Our ref: MP10_0057
File: 10/08342

**PROJECT APPLICATION FOR RESIDENTIAL DEVELOPMENT AT
132-138 KILLEATON STREET, ST IVES (MP10_0057)**

SCHEDULE 1 – DEPARTMENT OF PLANNING KEY ISSUES

SITE SECTION A-A

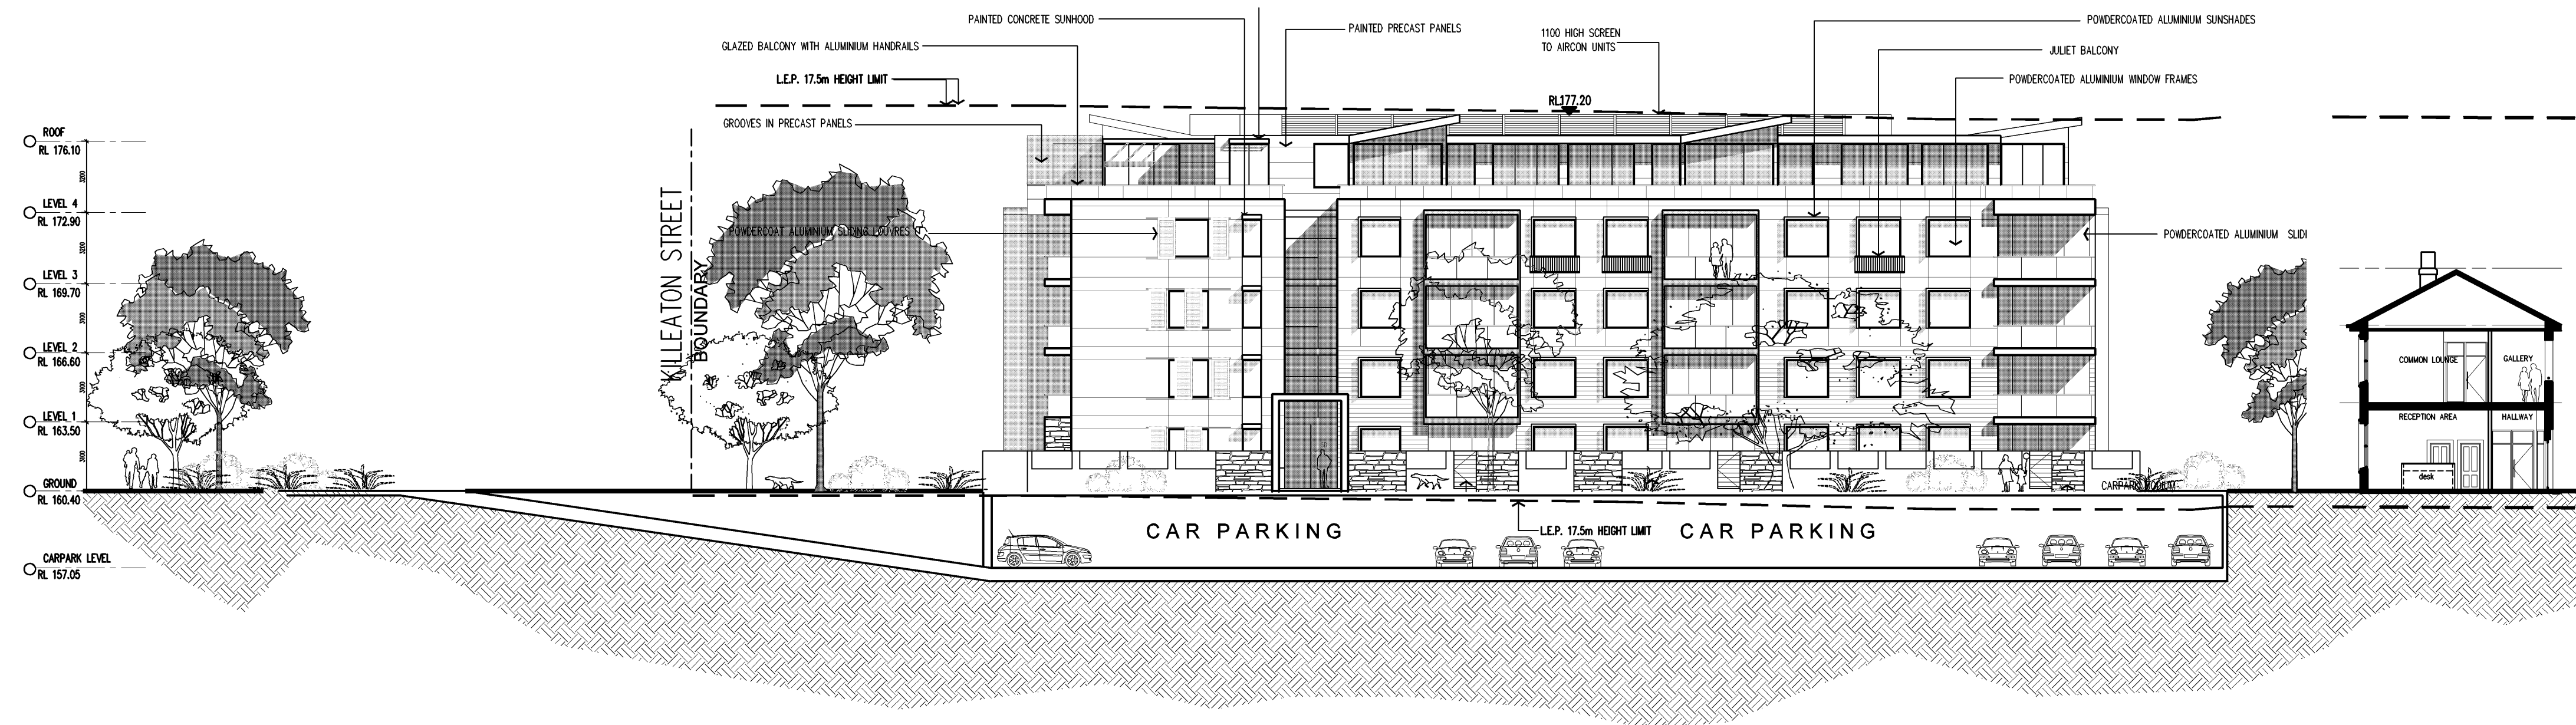
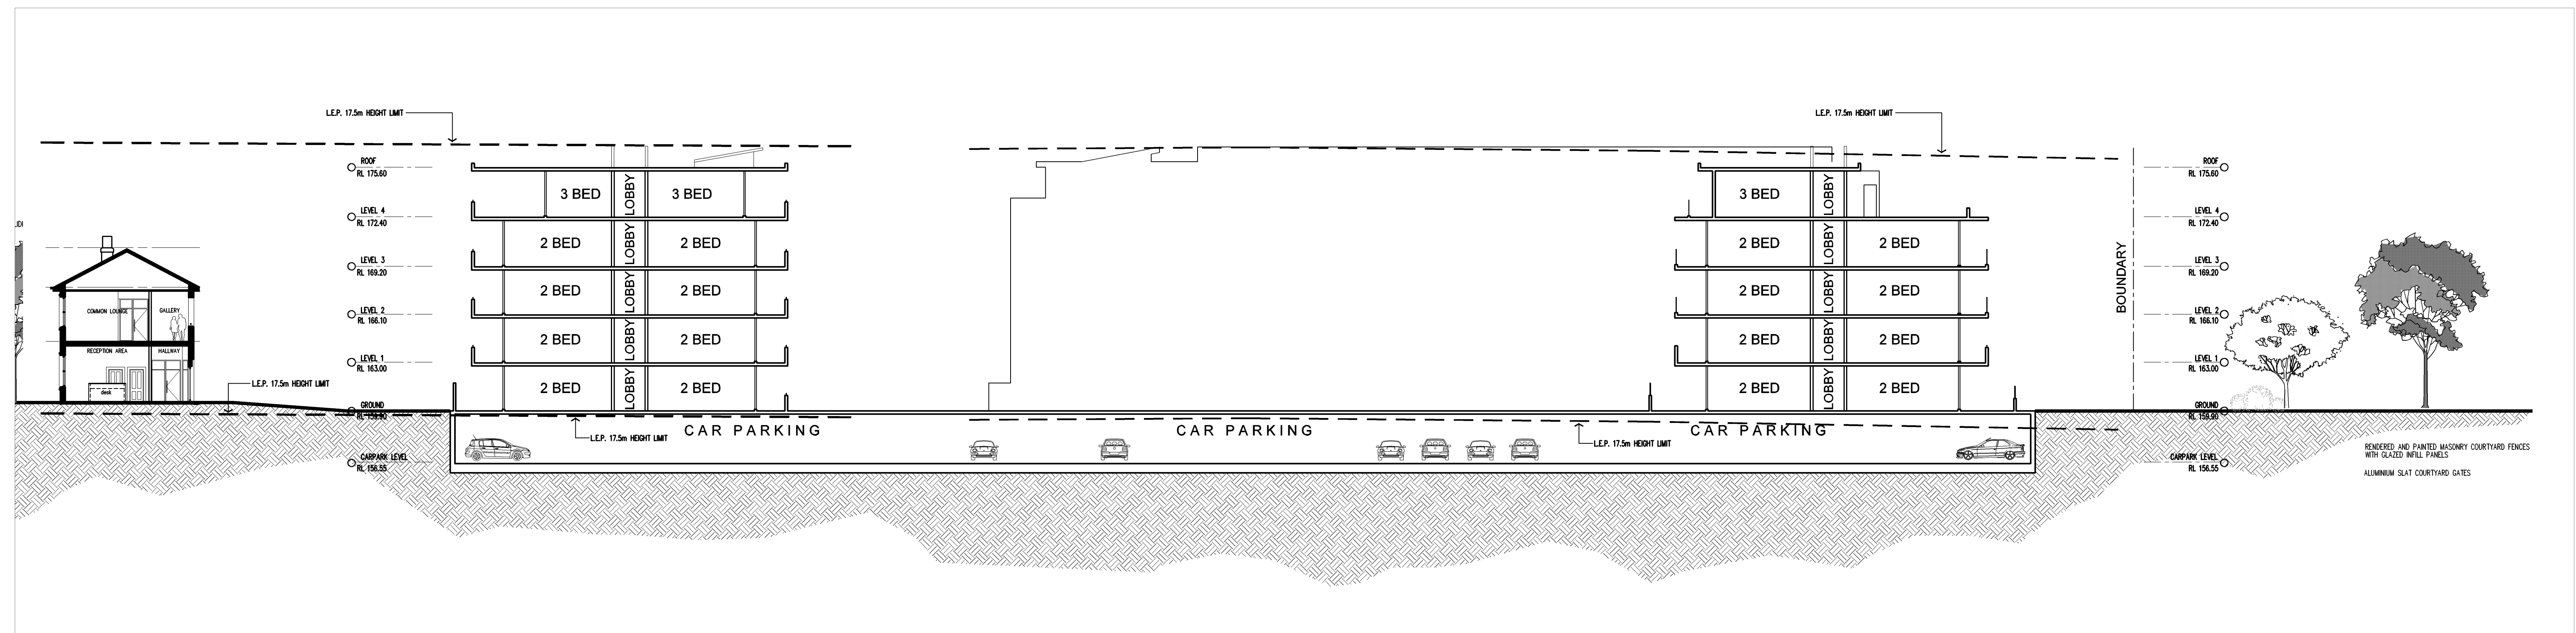
Amended plans should be provided which demonstrate that all areas of the basement car park protrude no more than 1 metre above existing ground level to ensure compliance with the prevailing height control. Clarification of Gross Floor Area/FSR calculations is to be provided, in accordance with the definition in the Ku-ring-gai LEP (Town Centres) 2010.

- Plans, long sections and cross sections detailing the relationship of proposed finished ground levels and basement level with existing natural ground levels.
- Plans and sections indicating the extent of cut and fill required across the site and adjacent all site boundaries, including calculations of proposed fill to be placed on site.
- Dimensioned plans which address **Issue 1** above are required, including revised shadow diagrams and a clear illustration of GFA inclusions, is required to be submitted.
